CITY OF ALBUQUERQUE

July 18, 2017

Re: Aztec Special Education Facility
2611 Eubank Blvd.
Traffic Circulation Layout
Architect's Stamp XX-XX-XX (H20D033)

Based upon the information provided in your submittal received 7-13-17, the above referenced plan cannot be approved for Building Permit until the following comments are addressed:

TYPE OF APPROVAL/ACCEPTANCE SOUGHT:

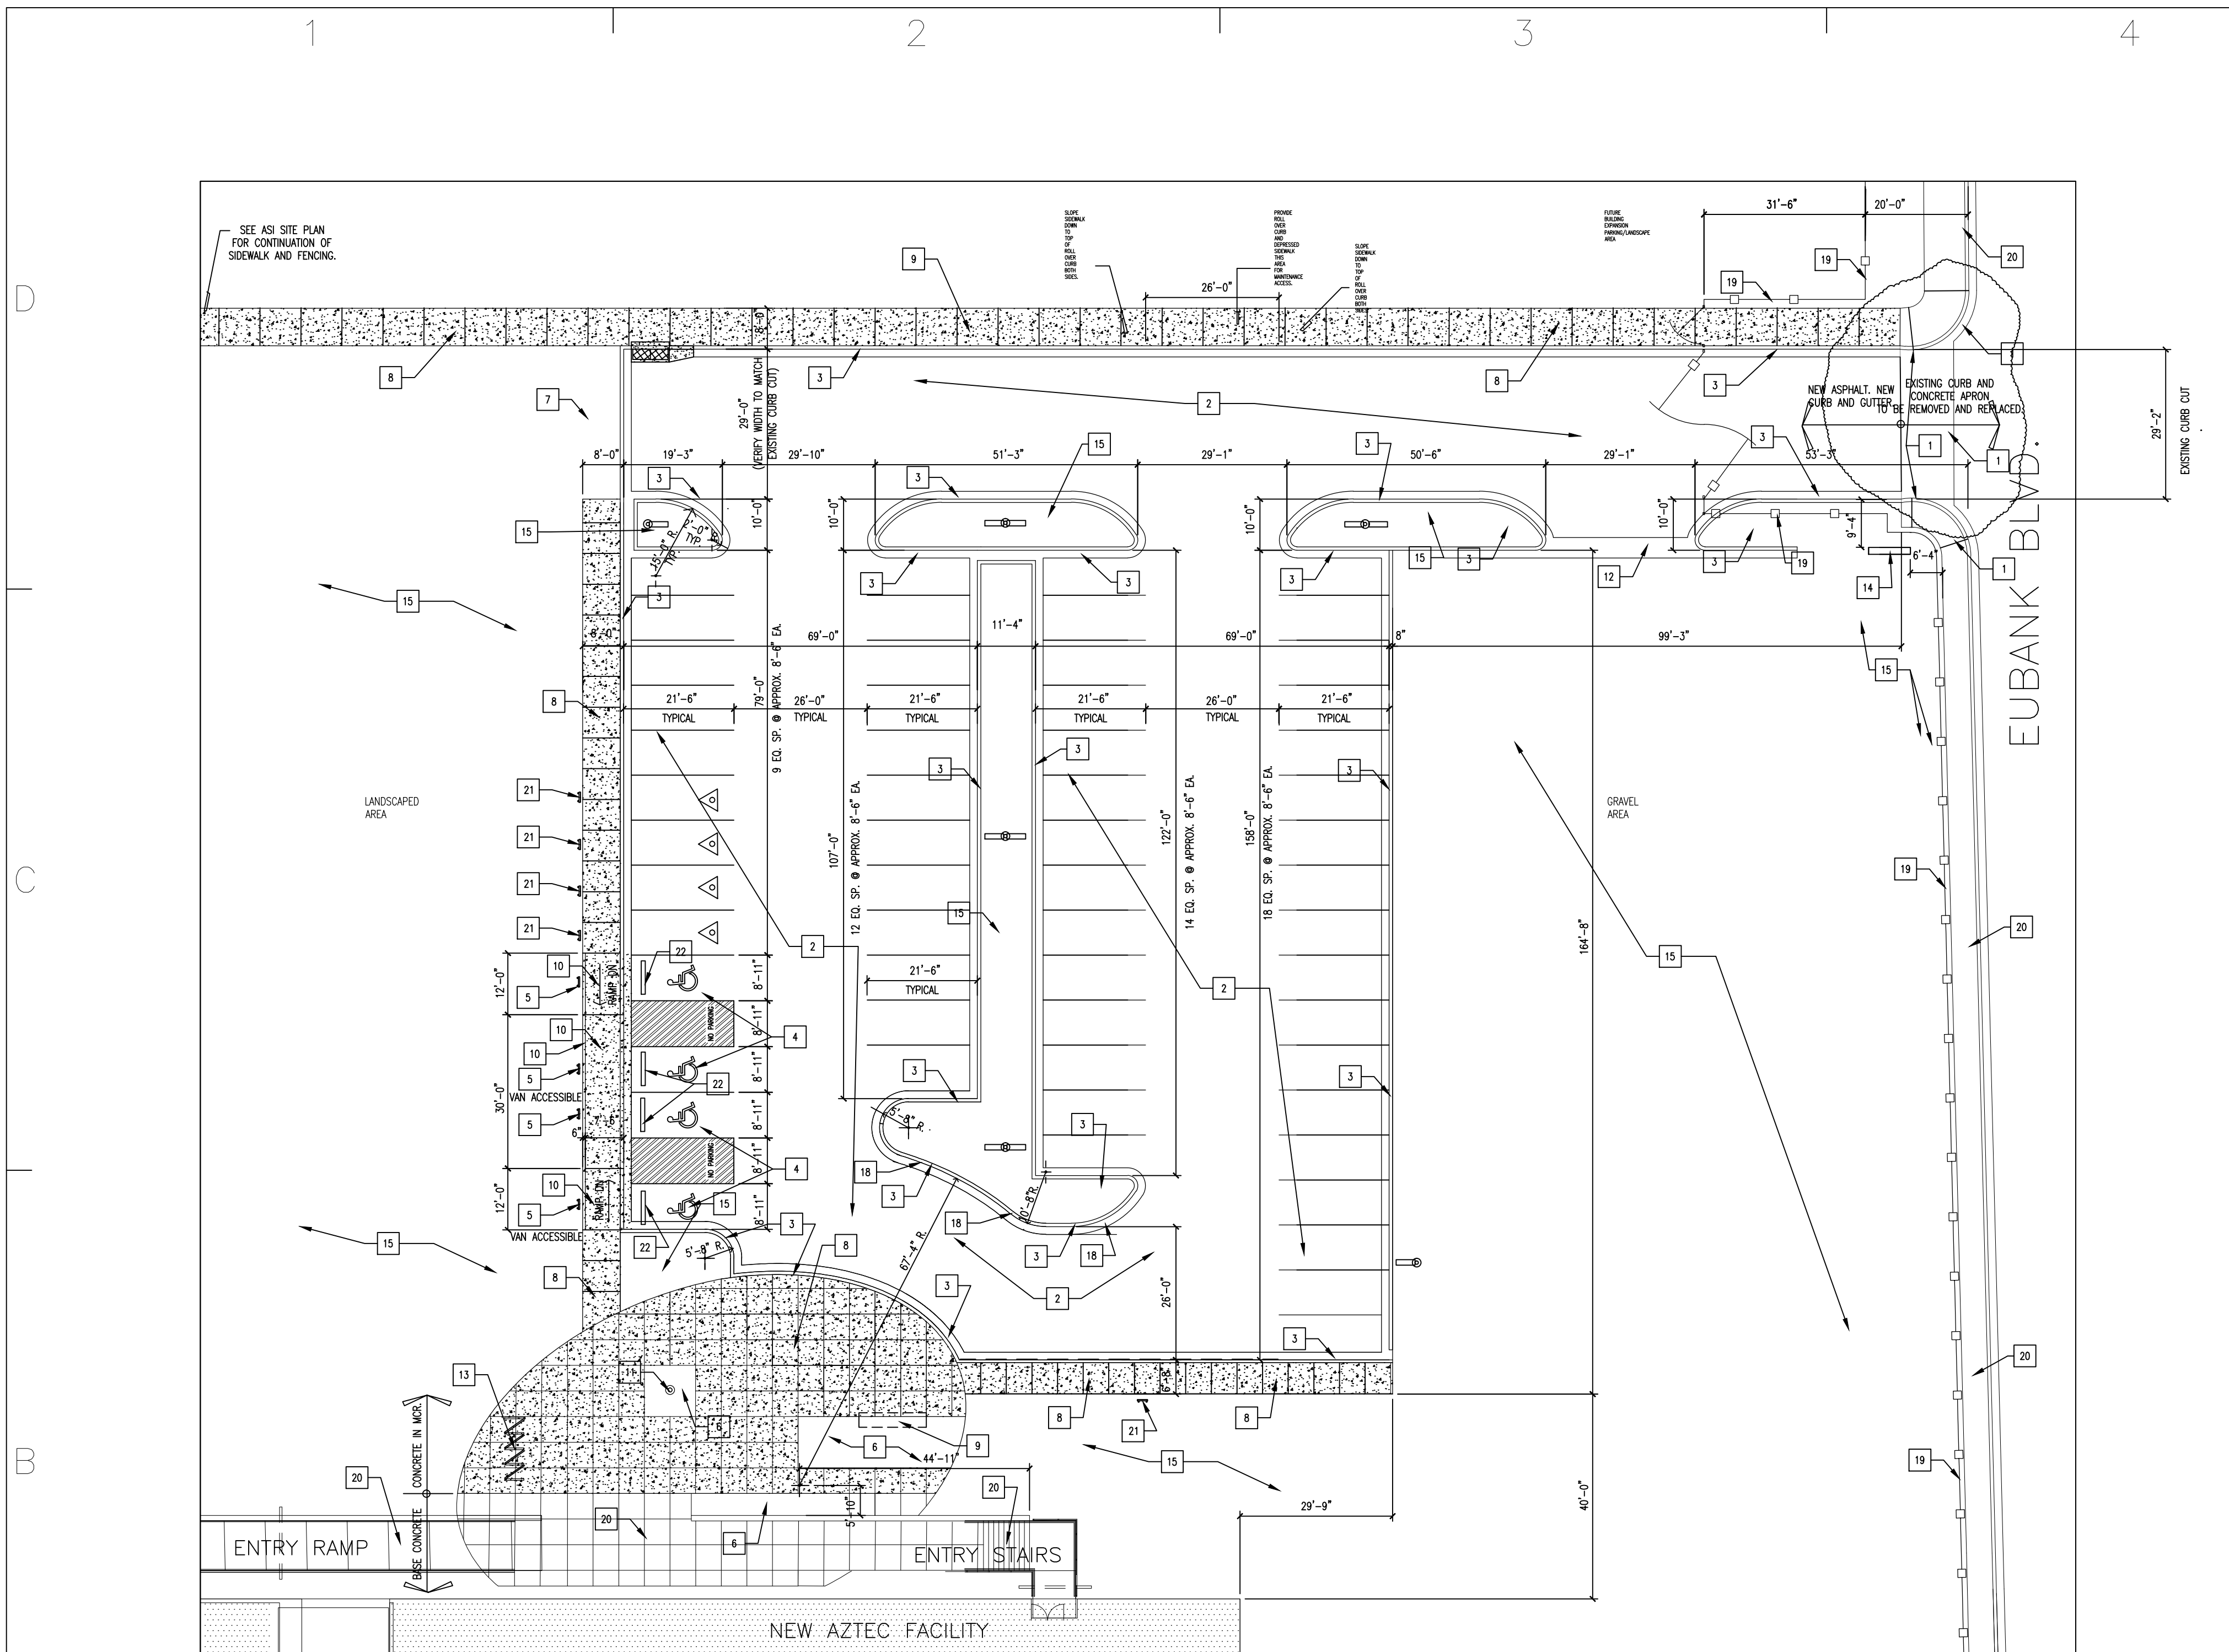
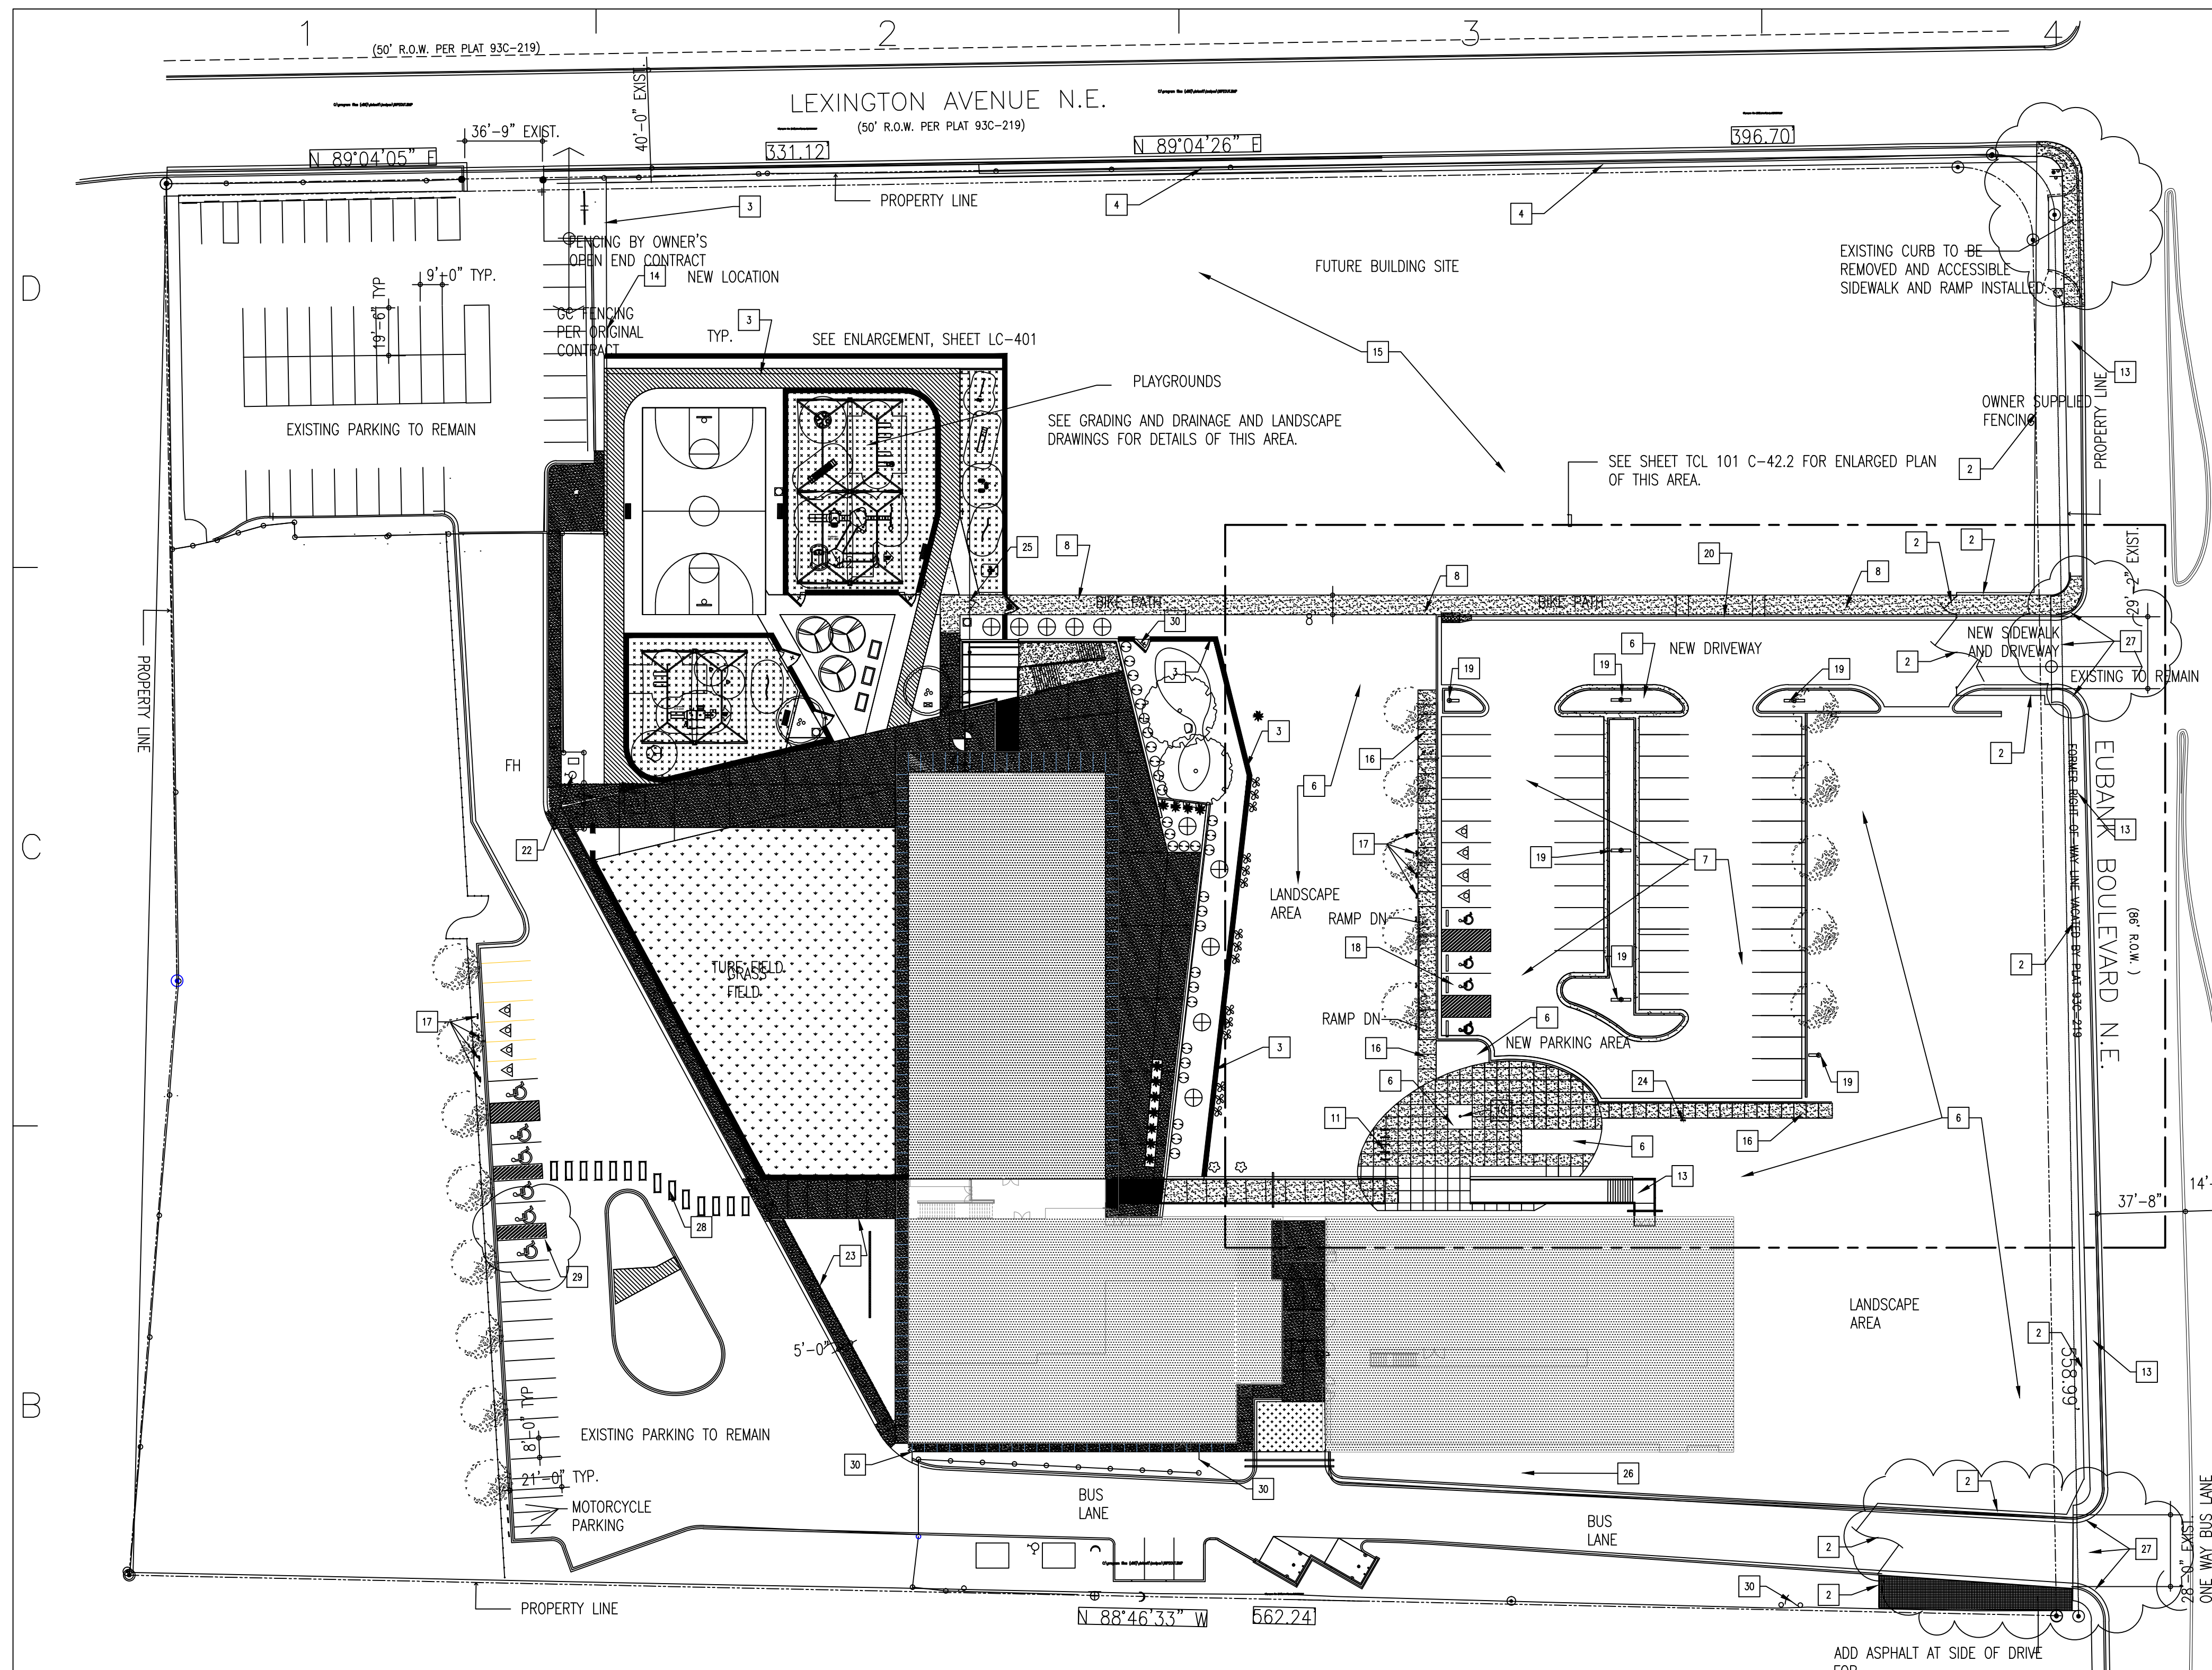
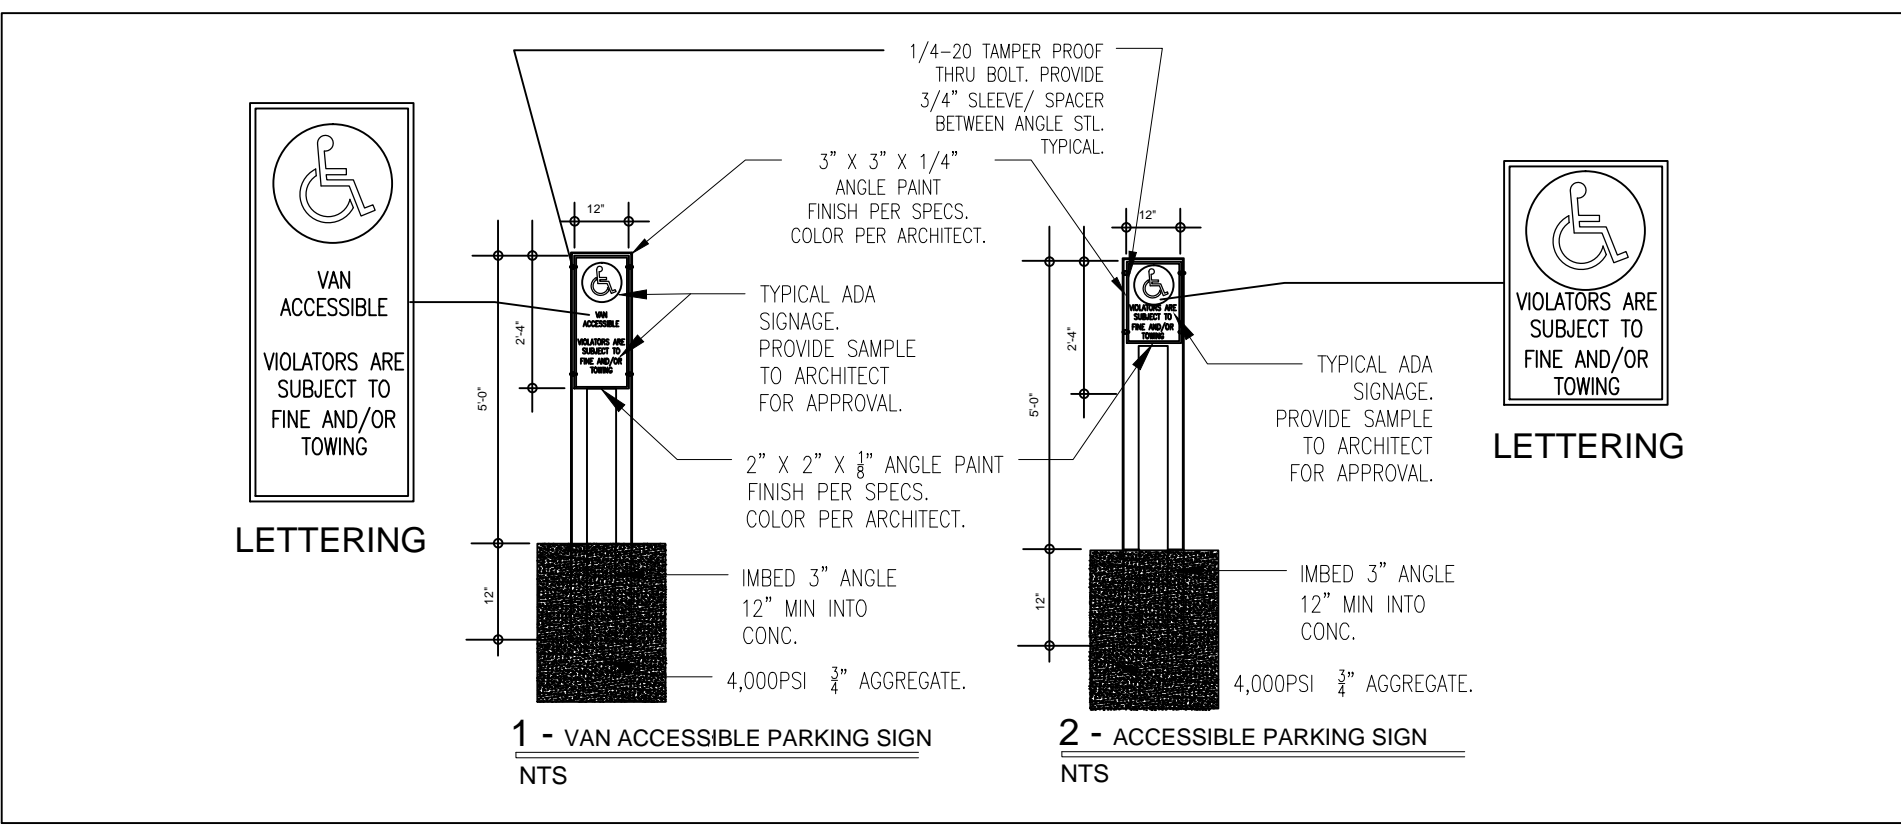
1. Please show a vicinity map showing the location of the development in relation to streets and well known landmarks.
2. The traffic circulation layout must be stamped, signed, and dated by an engineer or architect licensed in the state of New Mexico.

3. List the number of parking spaces required by the zoning code as well as the proposed number of parking spaces including bicycle and motorcycle parking.

4. Identify the right of way width, medians, curb cuts, and street widths on Eubank and Lexington.
5. Clarify existing property lines and proposed property lines.

6. Please list the width and length for all existing and proposed parking spaces. Some dimensions are not shown.
7. The handicap accessible spaces must be a minimum of 8.5 ft. in width.

8. The handicap accessible spaces must include an access aisle. Van accessible aisles should be 8ft wide; all others should be 5ft wide.
9. The ADA accessible parking sign must have the required language per 66-7-352.4C NMSA 1978 **"Violators Are Subject to a Fine and/or Towing."** Please call out detail and location of HC signs.

10. The ADA access aisles shall have the words **"NO PARKING"** in capital letters, each of which shall be at least one foot high and at least two inches wide, placed at the rear of the parking space so as to be close to where an adjacent vehicle's rear tire would be placed. (66-1-4.1.B NMSA 1978)

11. Show all drive aisle widths and radii. Some dimensions are not shown.
12. Show all sidewalk widths. Some dimensions are not shown.

13. Please provide the details sheet number C-42.2
